Planning Application Reference No.: 3/2024/0196

Address of Development: HAWTHORNE FARM, CLITHEROE

Planning Application 3/2024/0196 Approval of details reserved by Conditions 9 (surface water sustainable drainage scheme) and 17 (boundary treatment) of planning permission 3/2019/1104.

Persimmon Homes Lancashire Persimmon House, Lancaster Business Park, LA1 3RQ Phone: 01524542000		Development	
Drawing Title 3000 Screen & Trellis		Date 02/24	Scale 1/20@A3
Drawing Status Planning Detail		Drawing Ref LSD.BT.F05.06	Drawn / Checked by - Rev -

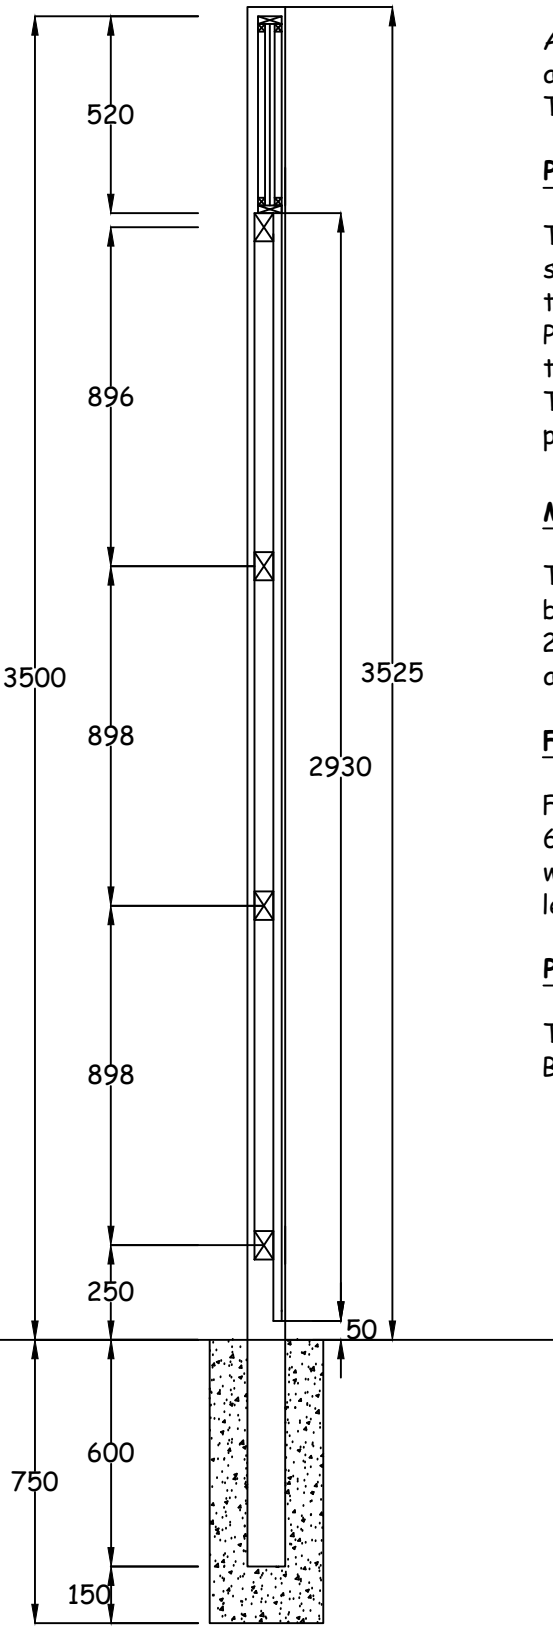
Comments: Further to my previous comment I wish to state that there is no way at all should Persimmon be allowed to put up fence as high as 13.5 m in such close proximity to our properties, It

Development	Hawthorne Farm		
Location	Clitheroe		
Marketing Name			
Drawing Title	Sections A-A & B-B & C-C		
Drawing Number	SLF.PL01.6		
Revision	Scale @ A2	1:200	
Drawn By	LA	Date Started	Feb 24
 Persimmon Persimmon Homes (PLC) Phone: 01524 542000

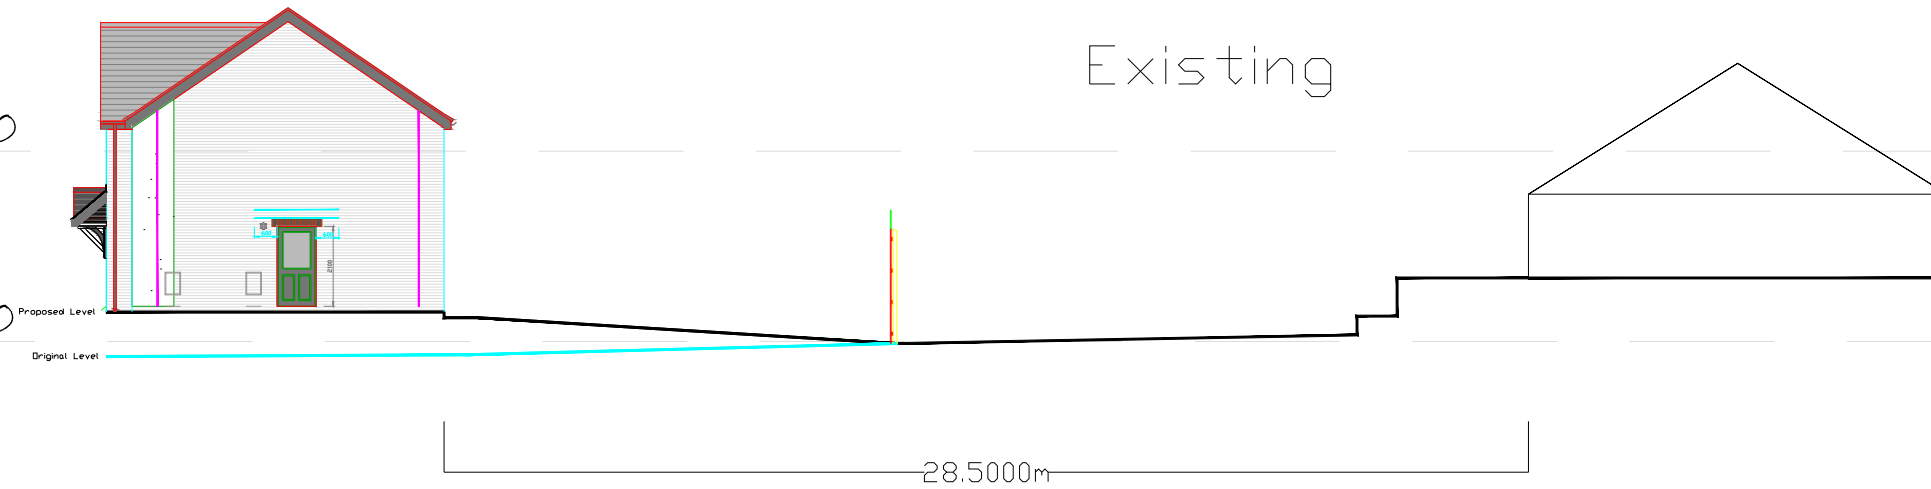
Tills has always been so	Inclent to avoid the regular mood was	ter seem in priotos previousty submitted
The cross section	indicates that	and proposes a
retaining wall at		– a raise of over a meter
from current levels and	not the 60cm suggested in the plans.	. This would
		which will
